M60/M62/M66 Simister Island Interchange

TR010064

7.16 APPLICANT'S RESPONSE TO ISH1 SUPPLEMENTARY AGENDA

Version	Date	Status of Version
P01	24 September 2024	Deadline 1

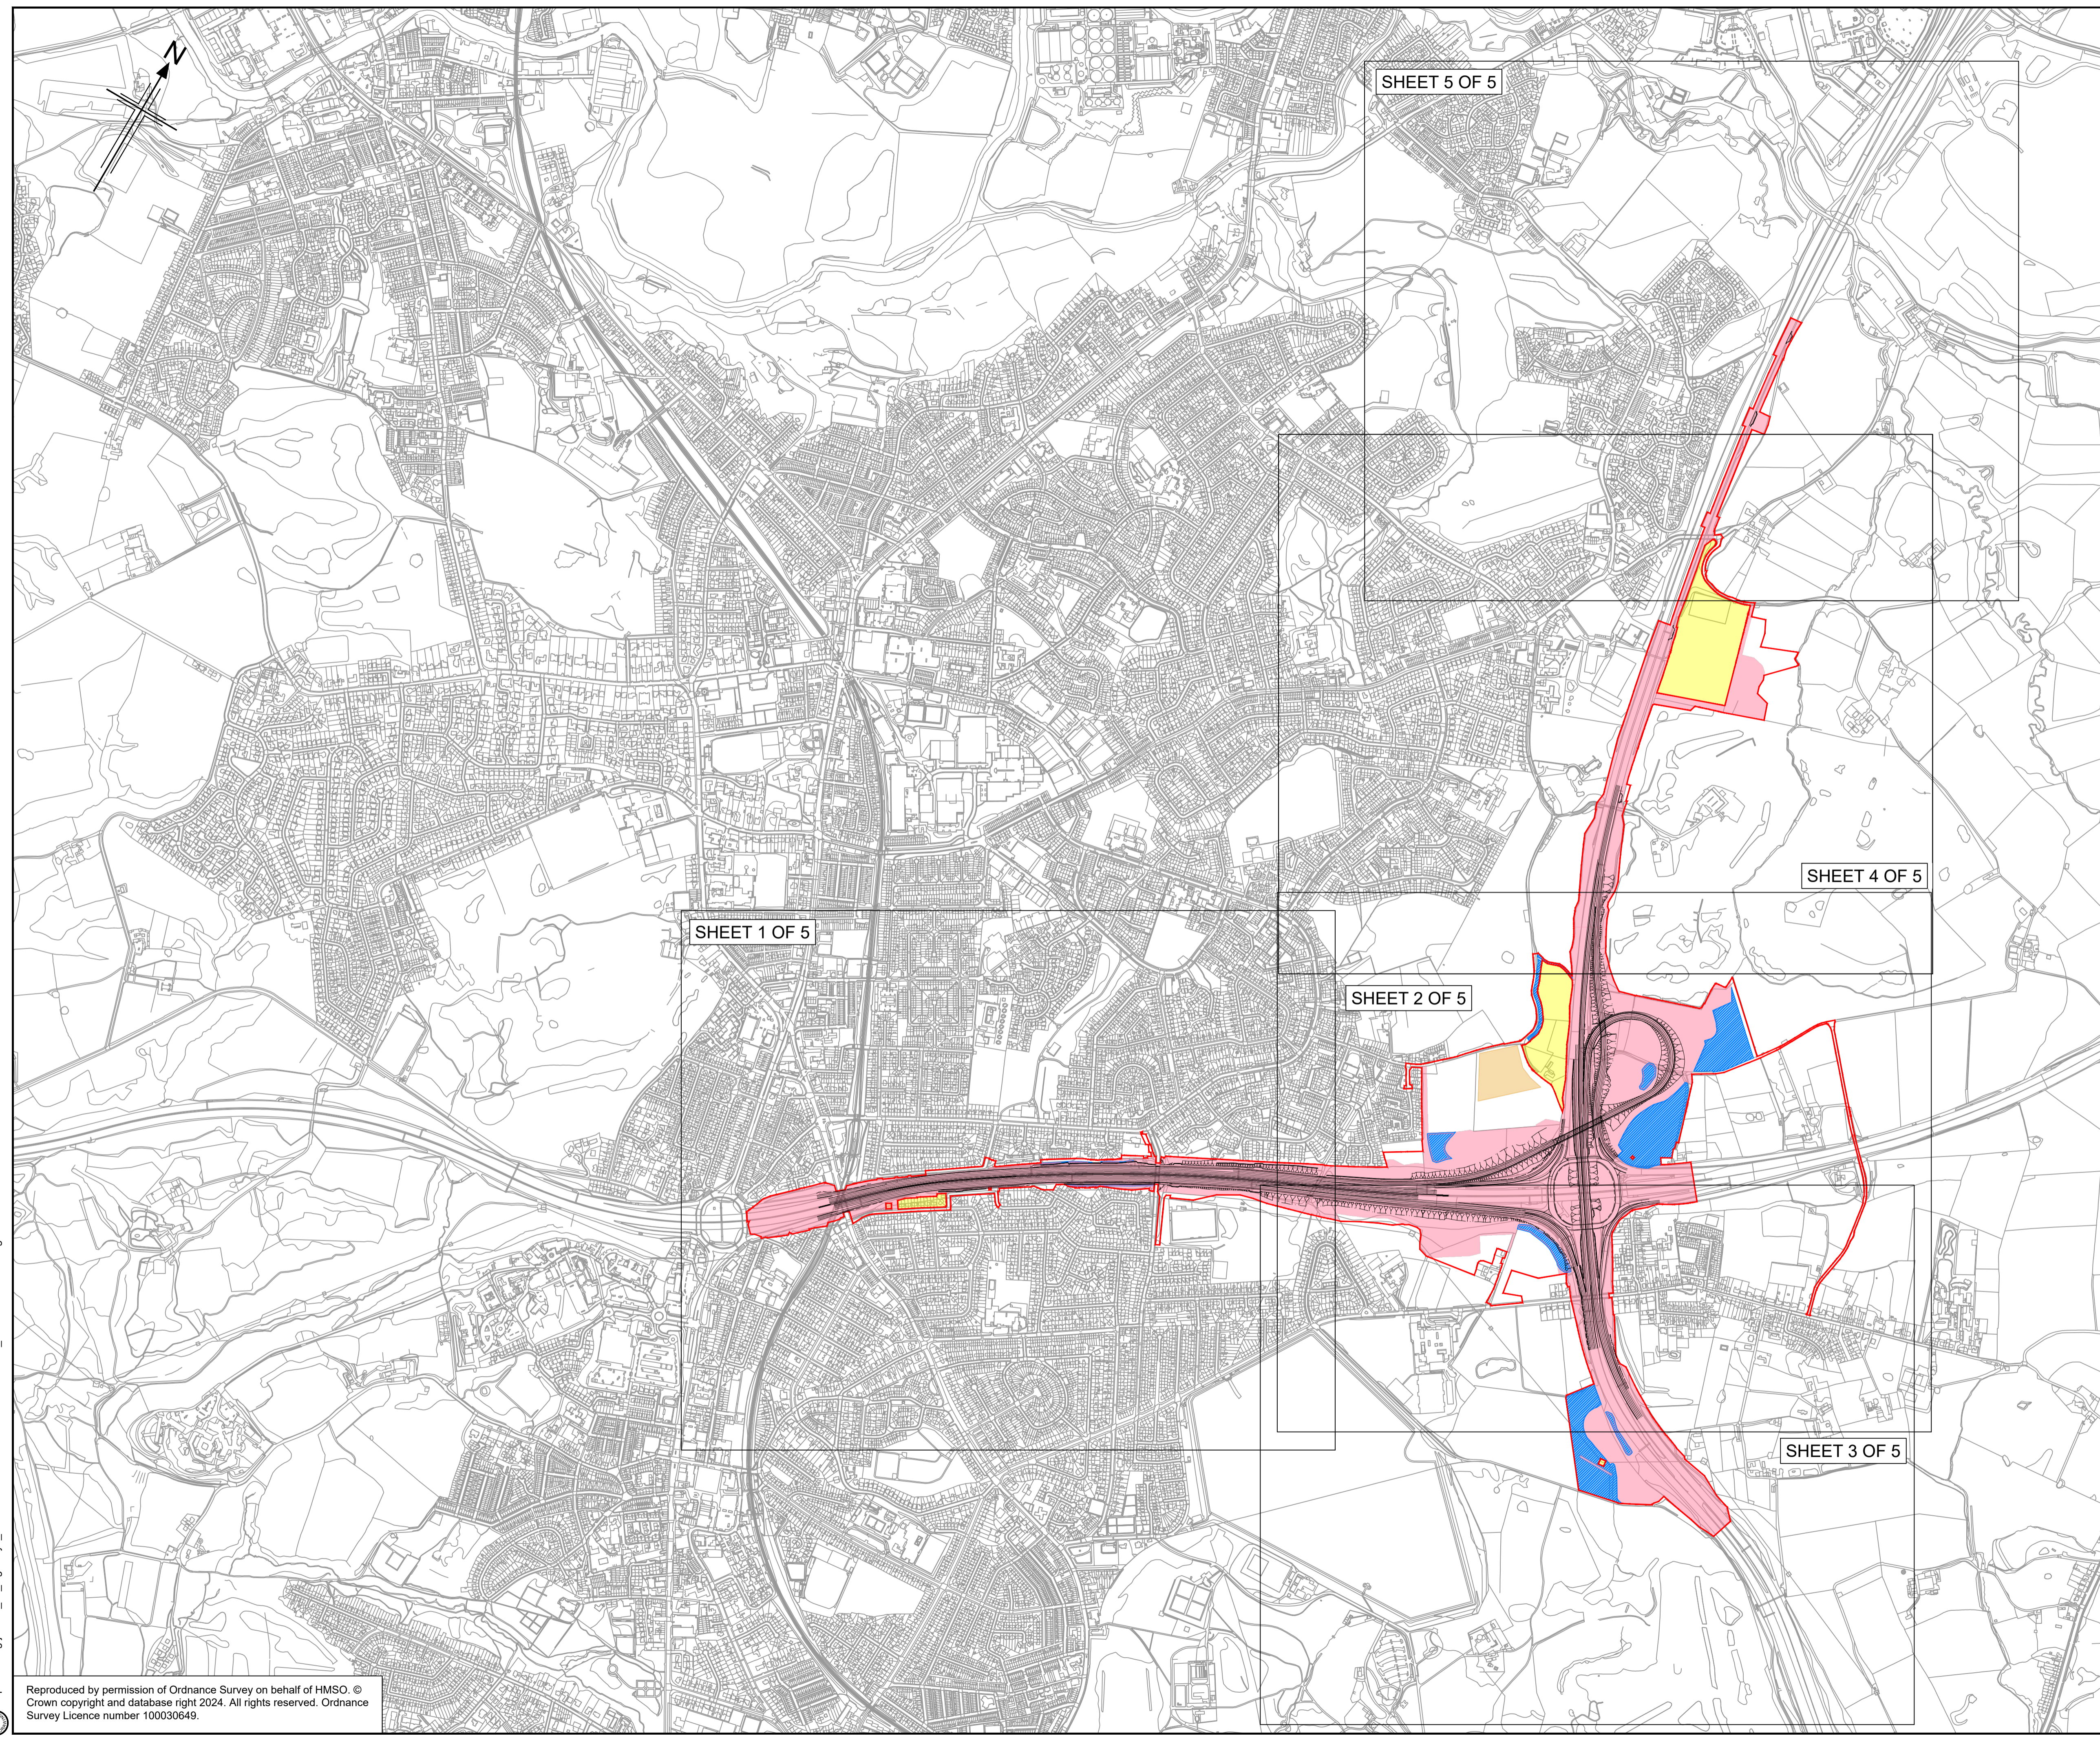
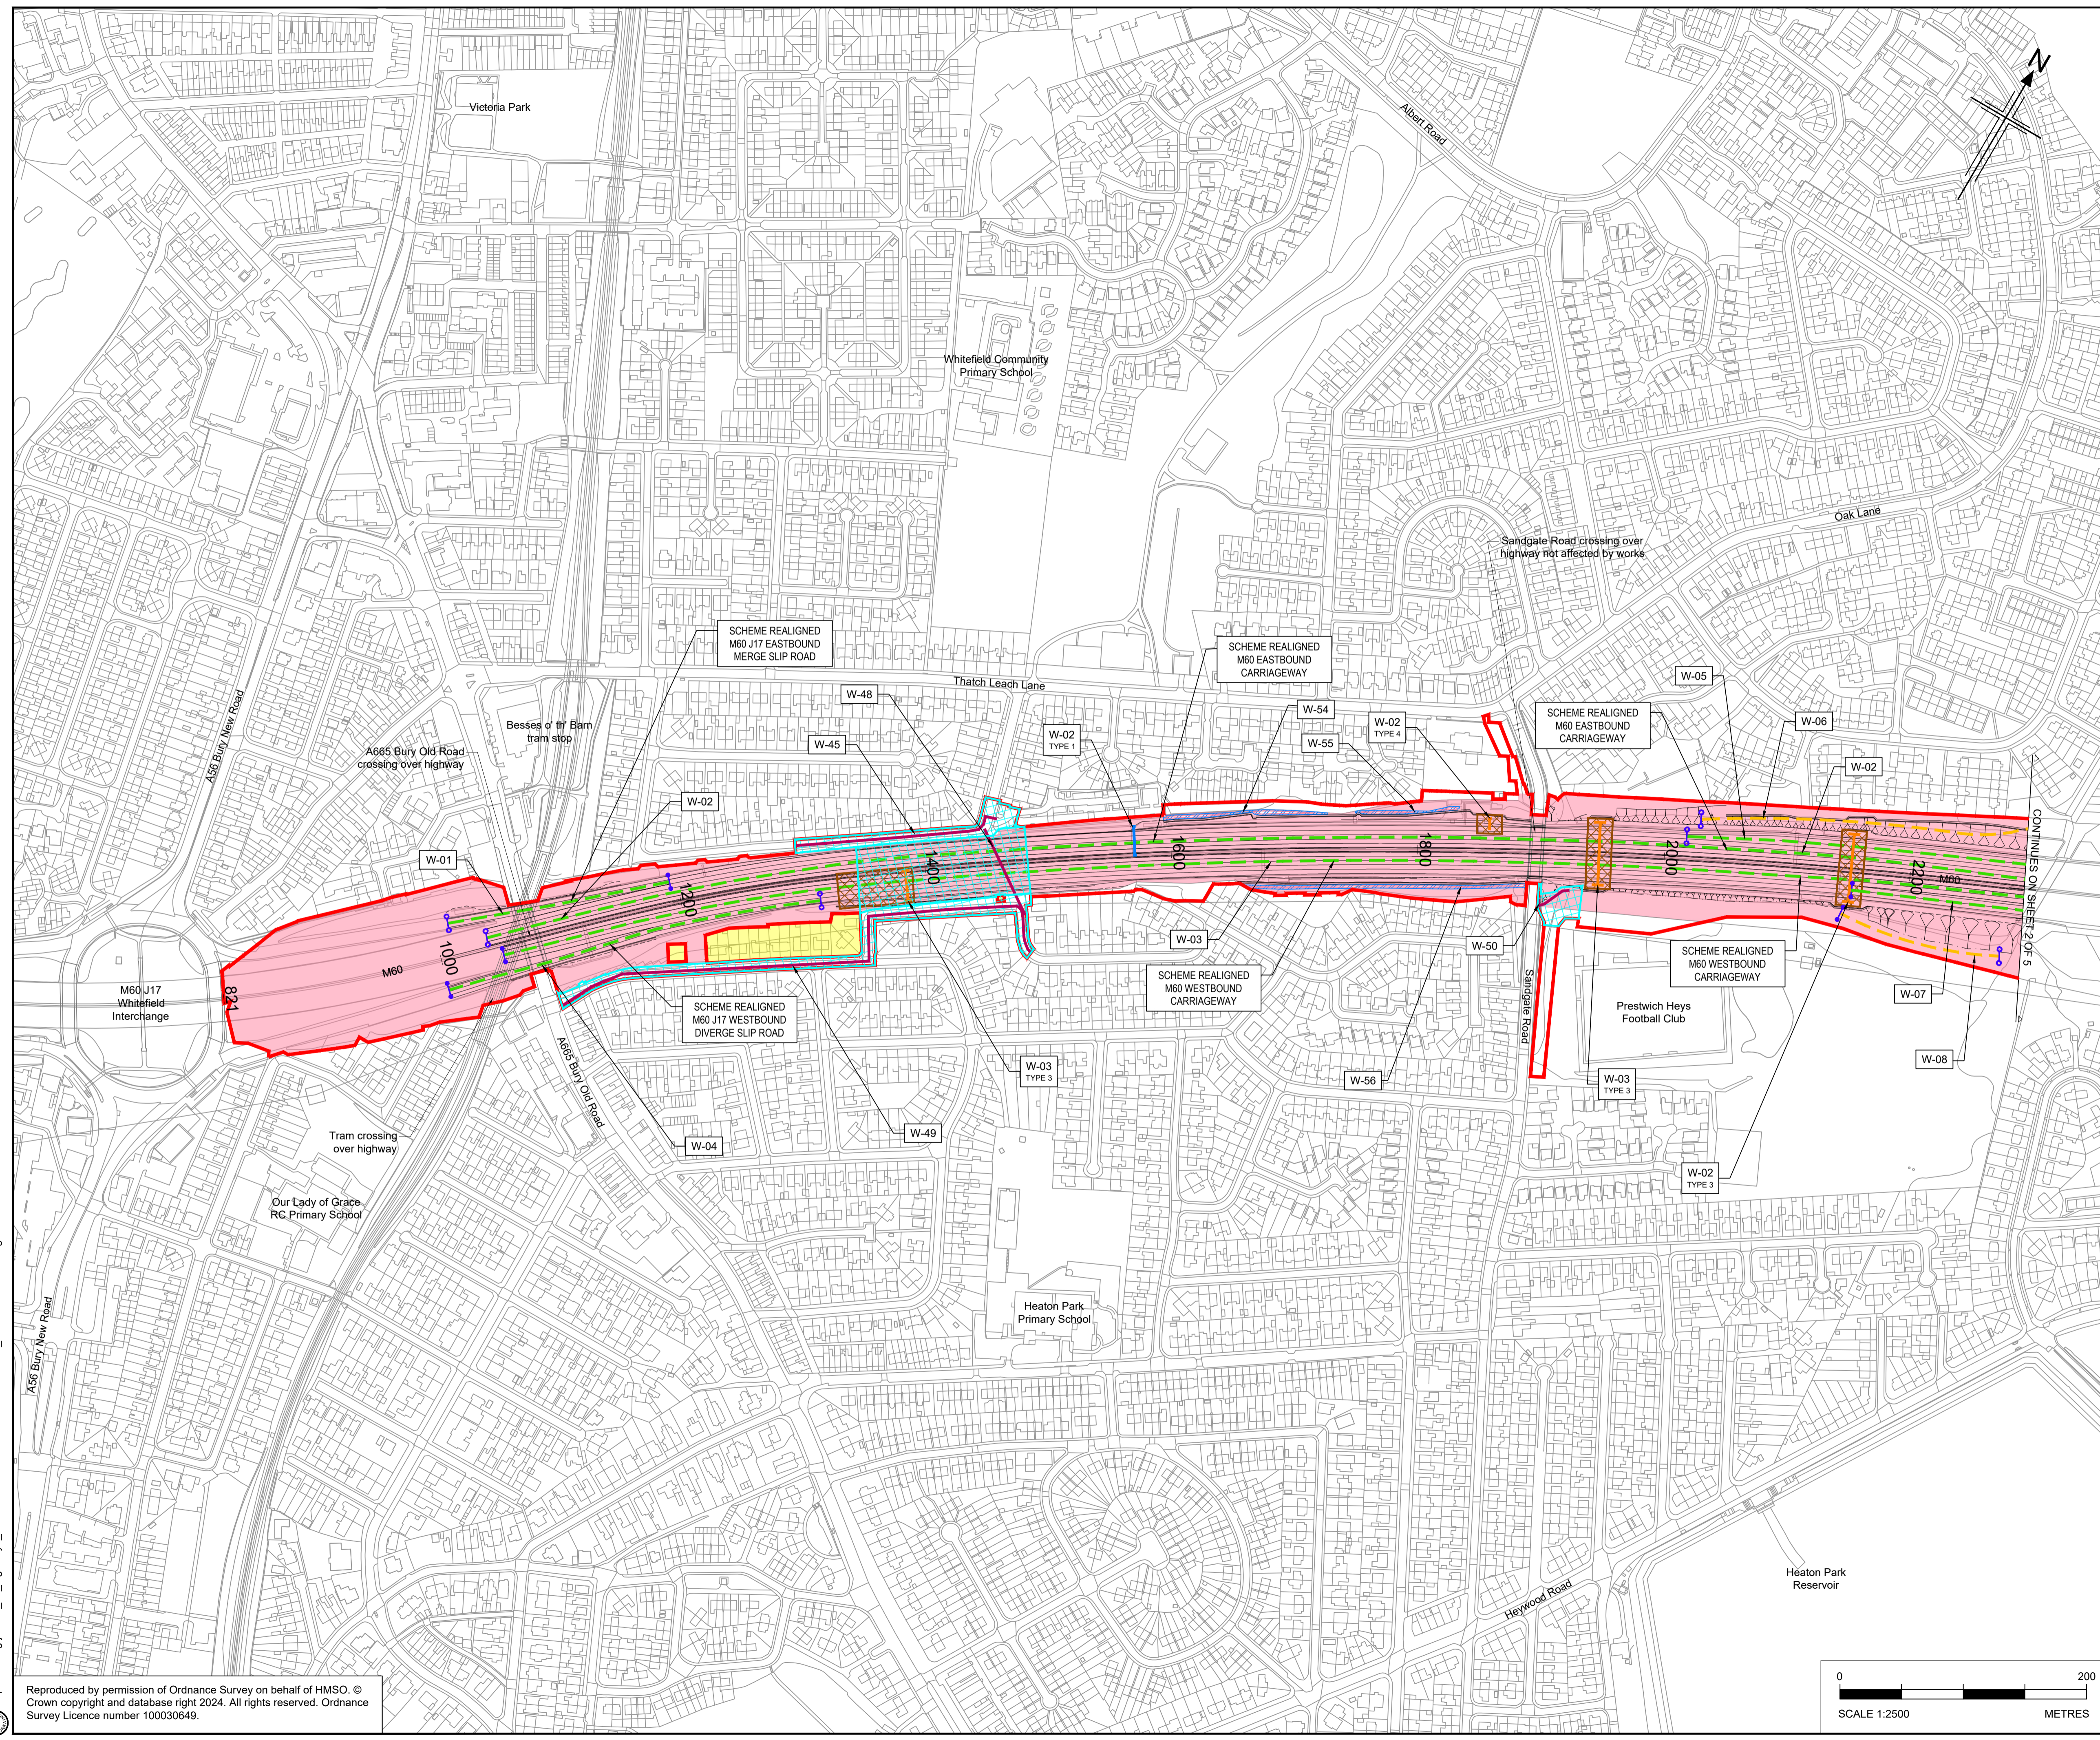
Part 2 – Principal Powers				
ISH1.A.13	Clarification	Applicant	Article 6(1)(a) – Limits of deviation The works plans [AS-006] referred to in paragraph (1)(a) identifies in the 'Key' to each of the plans limits of deviation applying to 'Highway Work', 'Scheme Gantry' and 'Utility Diversion'. Please clarify, what would 'Highway Works' include?	'Highway Works' includes all of the works comprising the authorised development except gantries and utilities. For instance, it would include carriageway, structures, environmental mitigation features (ponds etc.) and temporary works (haul routes etc.). The limits of deviation for gantries and utilities have their own limits of deviation because it is often requested and has become common practice.
